Your Ref: 2020/90119
Our Ref: W000665

Former Petrol Station, North Road, Kirkburton, Huddersfield - Discharge conditions 12 (Drainage) and 13 (Water Supply Protection) on previous permission 2016/93935 for demolition of existing petrol station and erection of 4 retail and residential units (within a Conservation Area) (modified proposal)

Yorkshire Water objects to the discharge of condition 12.

Title: DRAINAGE LAYOUT			
Job No: 2242	DRN: MM	Date: 24/12/2019	
Scale: 1:125 (A1)	CHK: UD	DRG. No.: ESE-DR-S-001: P1

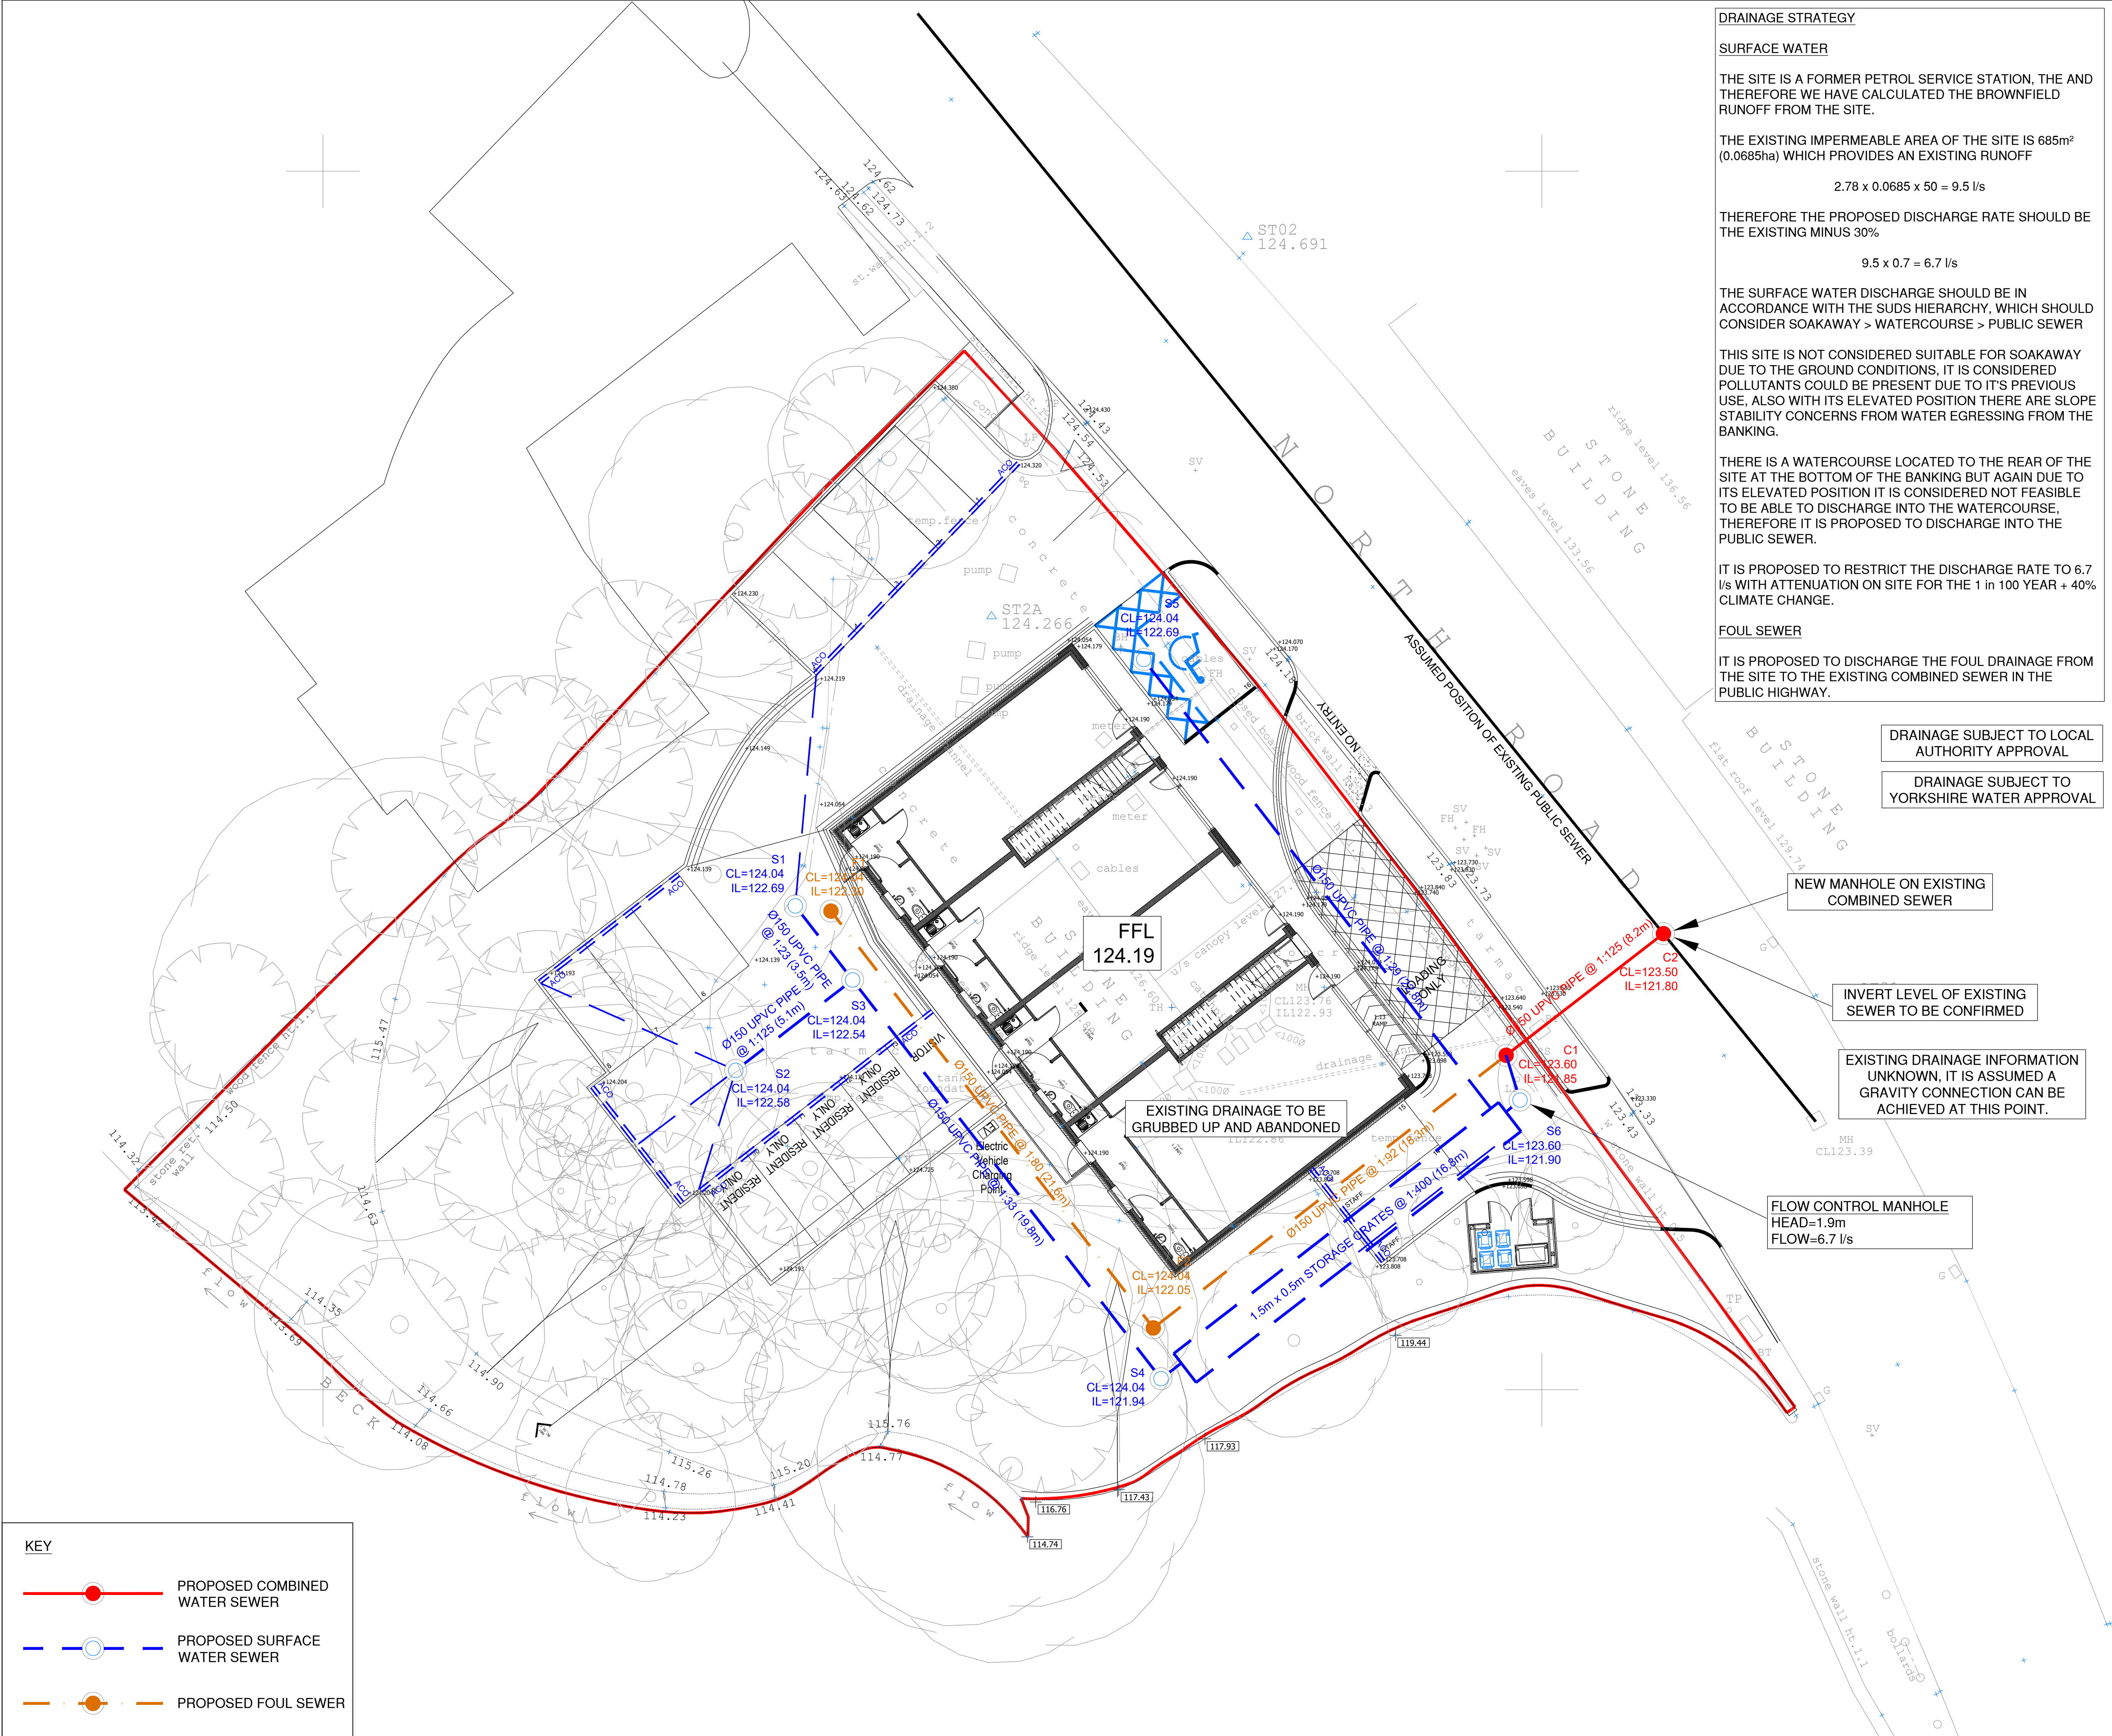
1) The submitted drawing ESE-DR-S-001 revision P1, dated 24/12/2019 indicated that surface water from the site will discharge to the public combined sewer network at 6.7 litres per second. This is unacceptable and the developer must provide evidence to demonstrate that surface water disposal via infiltration or watercourse are not reasonably practical before considering disposal to public sewer. It is understood that a watercourse (Dean Bottom Dike) is located adjacent to the site, which appears to be the obvious place for surface water disposal.

It would be extremely poor drainage practice to agree to this without satisfactory evidence to discount other methods of surface water disposal. We await further consultation prior to condition 12 being discharged.
